OXFORDSHIRE COUNTY COUNCIL'S RESPONSE TO CONSULTATION ON THE FOLLOWING DEVELOPMENT PROPOSAL

Application no: 22/00747/OUT

Proposal: Outline planning application for the development of up to 370 homes, public open space (including play areas and woodland planting), sports pitches and pavilion, drainage and engineering works, with all matters reserved (appearance, landscaping, layout and scale) except for vehicular and emergency accesses to Bicester Road.

Transport Schedule

Appendix C – Vehicle Tracking

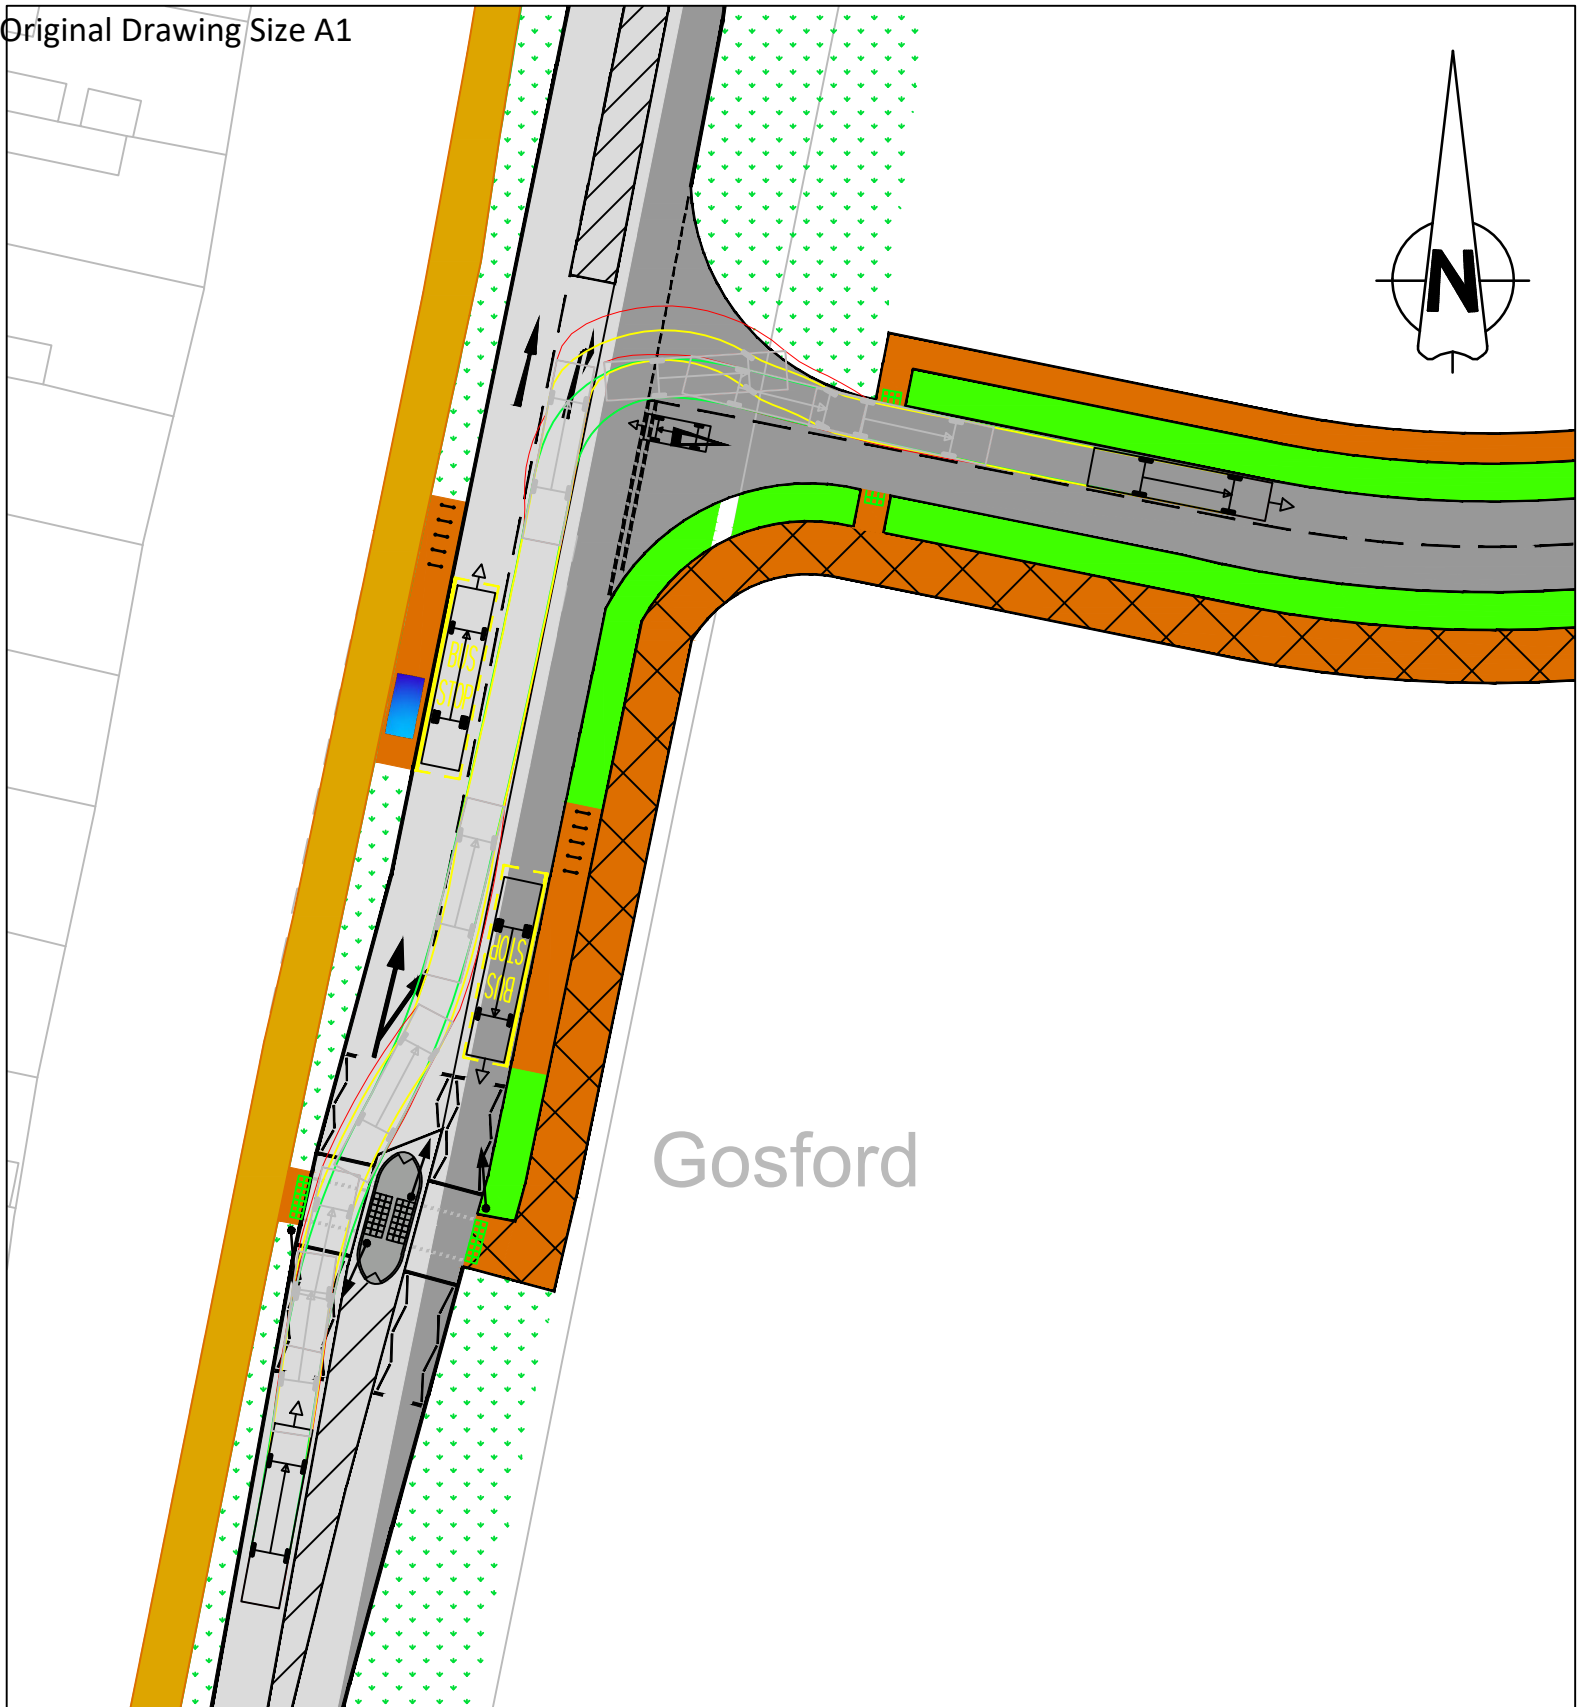
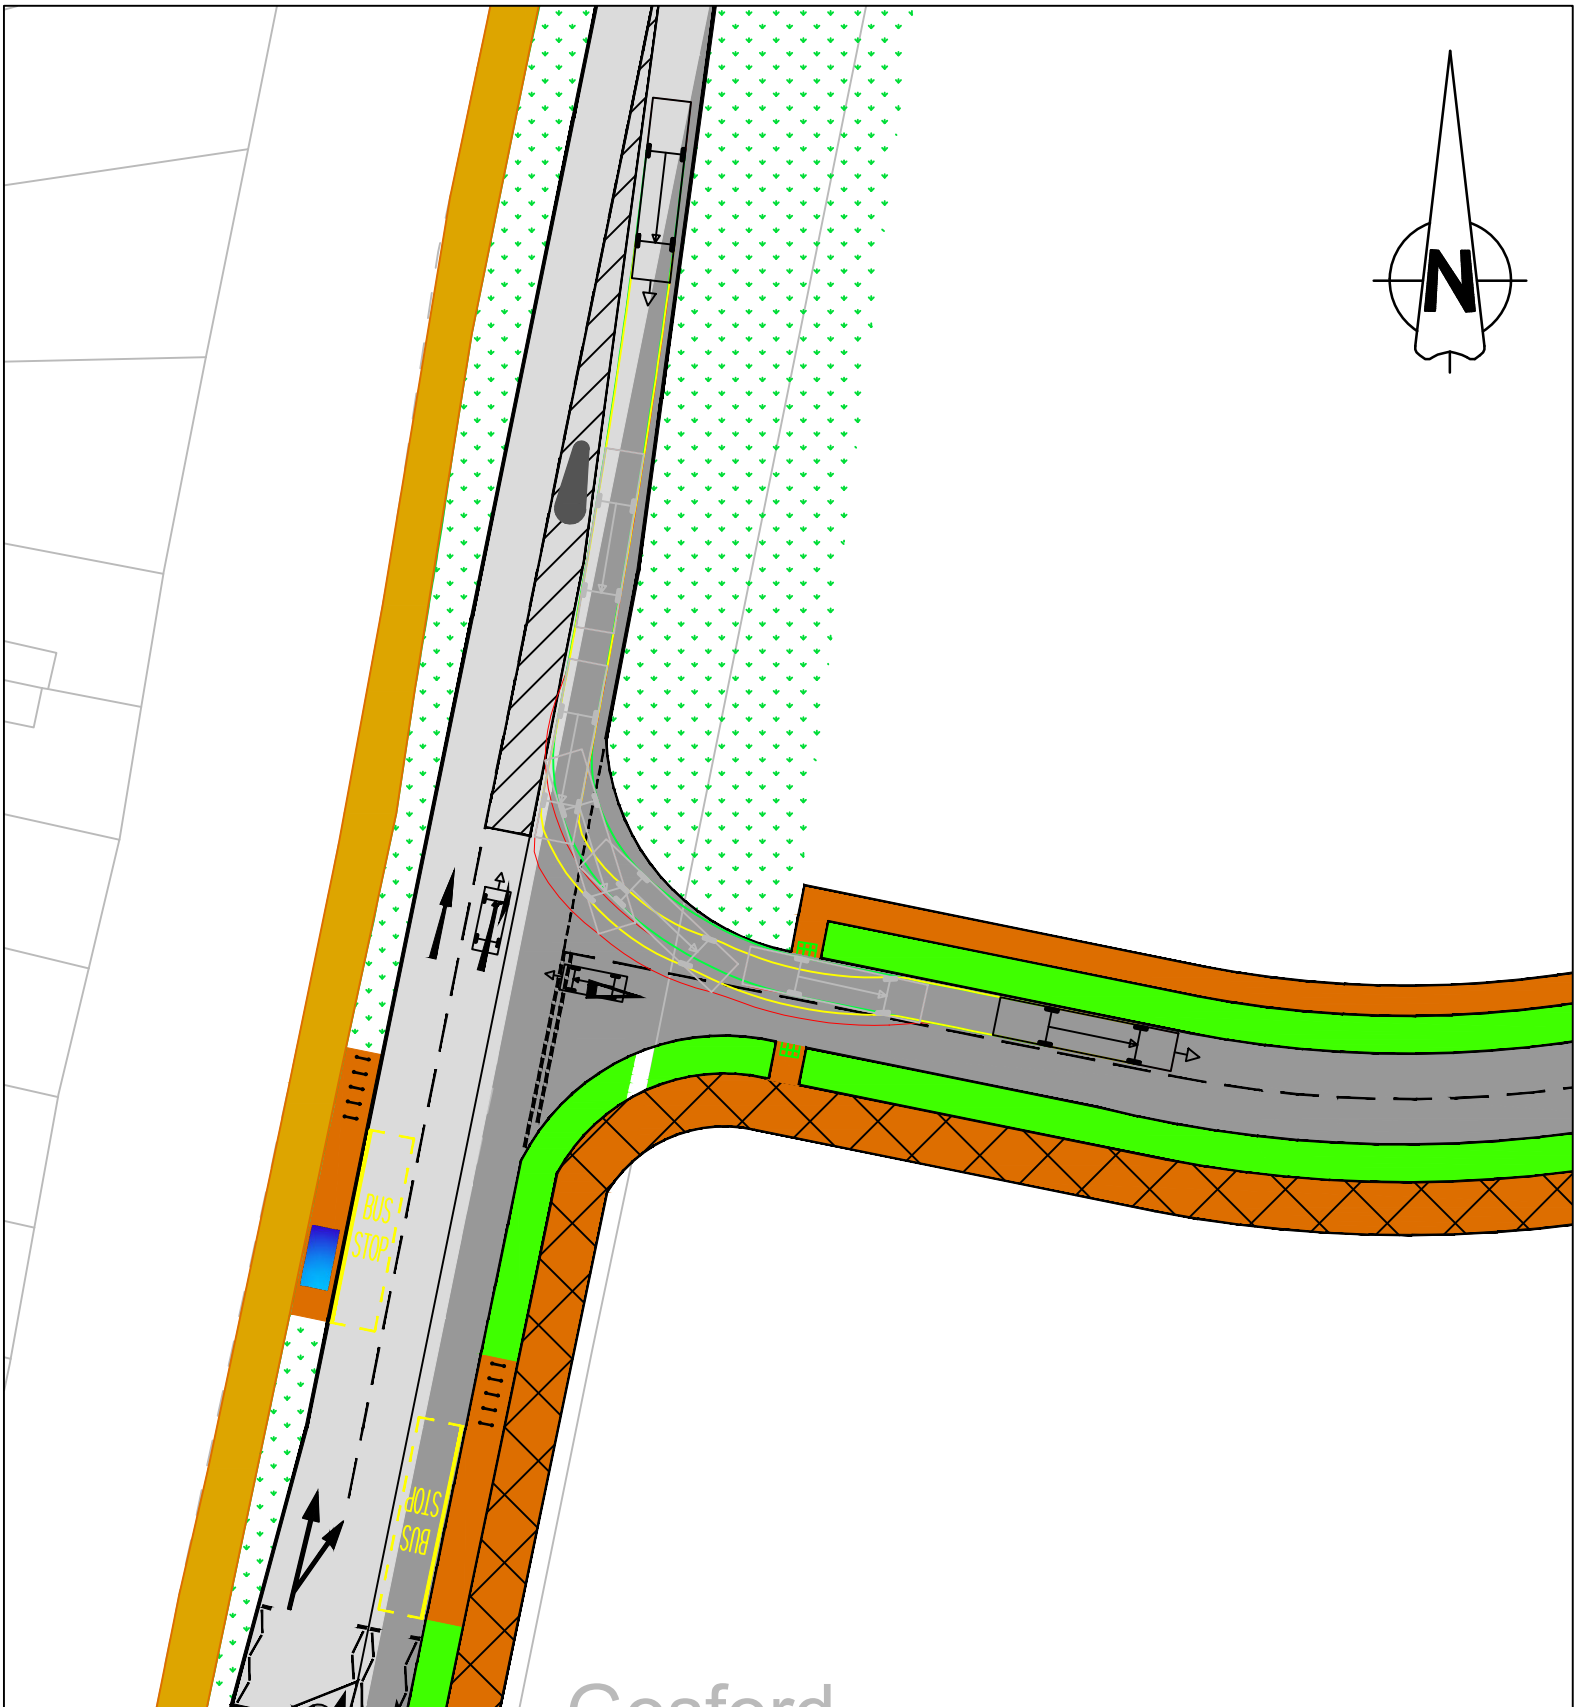
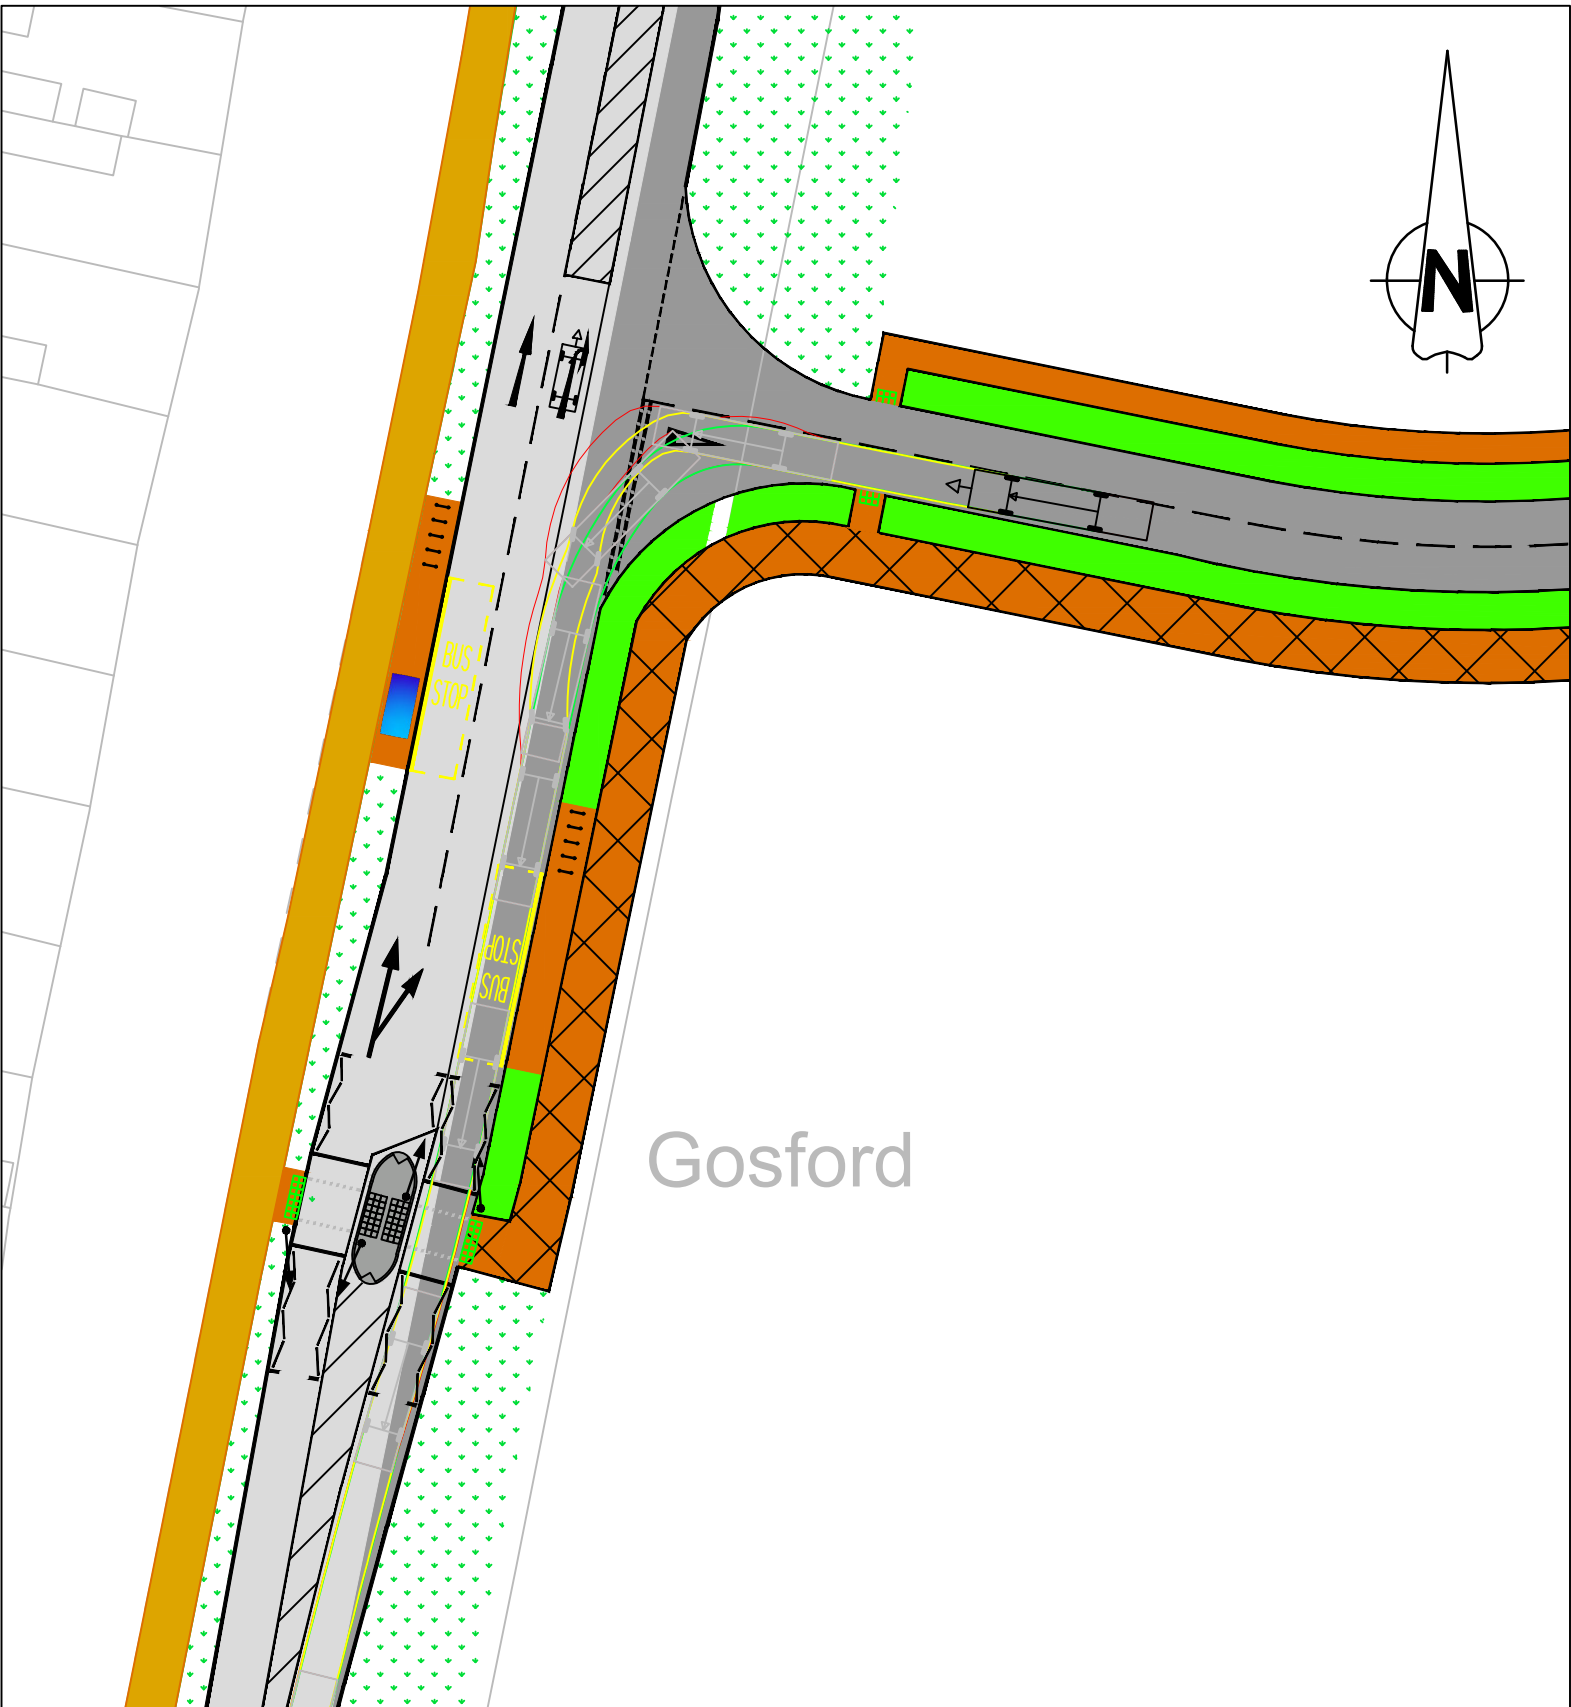
In our previous report, I noted through the submitted tracking drawings that the access geometry could not safely accommodate large vehicles without infringing into oncoming traffic particularly for the right turning lane. While the width of the access road has been increased to about 6m wide for the first 10metres, this has not improved the prevailing concern of affected incoming vehicles rather than the left turning vehicles. The tracking exercise on the revised junction still presents the same conflict between right turning arrivals and left turning exiting traffic.
